**WELWYN HATFIELD BOROUGH COUNCIL
EXECUTIVE DIRECTOR - PLANNING, PUBLIC PROTECTION AND GOVERNANCE**

Application No: 6/2020/3290/PN8
Location: 86 Bell Lane Hatfield AL9 7AY
Proposal: Prior approval for the erection of a single storey rear extension measuring 4.83m in depth, 3.00m in height and 2.80 to the eaves
Officer: Ms Kirsty Shirley

Recommendation: Refused

**Proposed Block Plan**

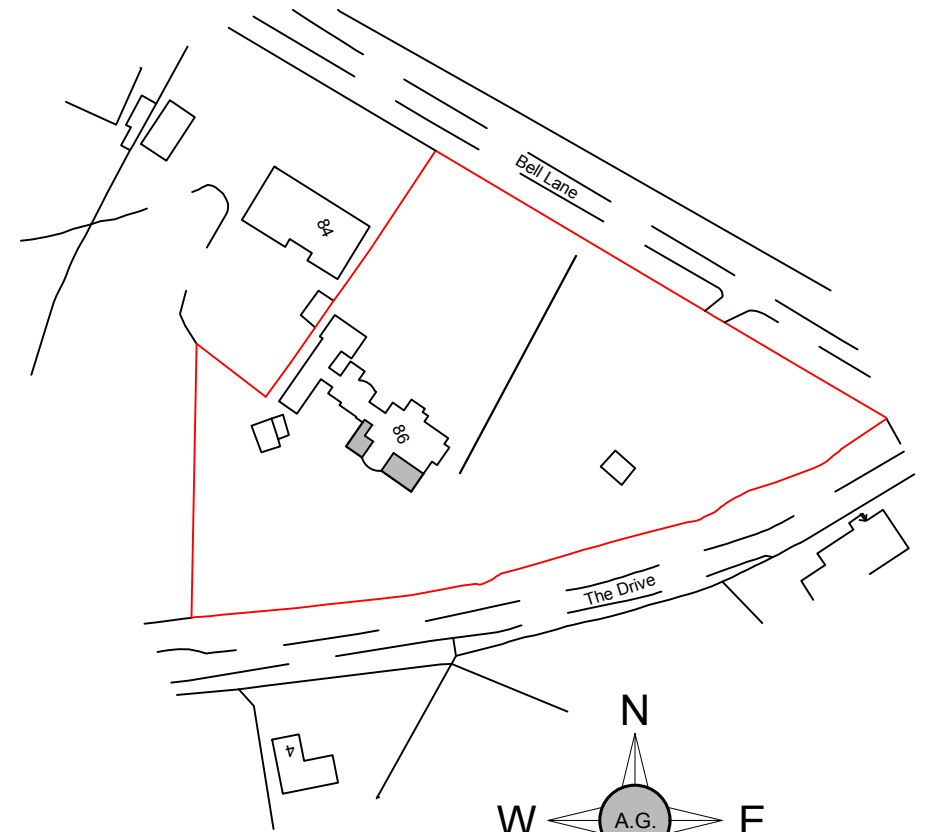
Two extensions are proposed which are shown on the proposed plans. No information is provided either within the application form or through the submitted drawings with regard to the height of the extension measuring 6.030m in width and 3.595m in depth. As a consequence, the height of this extension is not known and whether it meets the requirement of Schedule 2, Part 1, Class A of the Town and Country Planning (General Permitted Development) (England) Order 2015 as amended. Accordingly, the application for prior approval is refused.

The deepest part of the proposed extension is shown to be 4.83m on the application forms. However, the proposed floorplans show that this would be a greater depth, due to the design of the property. Consequently inaccurate information is provided with regard to the depth of the extension proposed and does not comply with the conditions set out in Schedule 2, Part 1, Class A of the Town and Country Planning (General Permitted Development) (England) Order 2015 as amended. An accurate assessment of the proposal is therefore unable to be given.

- 1. The submitted plans indicate two separate extensions. It is not clear the height of the extension proposed to the rear of the drawing room. Insufficient information has therefore been provided to enable the Local Planning Authority to properly assess the proposals and if the proposal would comply with Schedule 2, Part 1, Class A of the Town and Country Planning (General Permitted Development) (England) Order 2015 as amended.

- 2. A.4 (conditions) of Schedule 2, Part 1, Class A of the Town and Country Planning (General Permitted Development) (England) Order 2015 outlines that the developer must provide in writing how far the enlarged part of the dwelling extends beyond the rear of the original dwellinghouse and provide a plan showing the proposed development. However, there is an inconsistency with the proposed plans and the written depth of the proposed extension, which is shown in the application forms to be 4.83m. The proposed plans, show a deeper extension. Accordingly the information provided does not meet the requirements of Schedule 2, Part 1, Class A of the Town and Country Planning (General Permitted Development) (England) Order 2015 as amended and an accurate assessment is unable to be made.
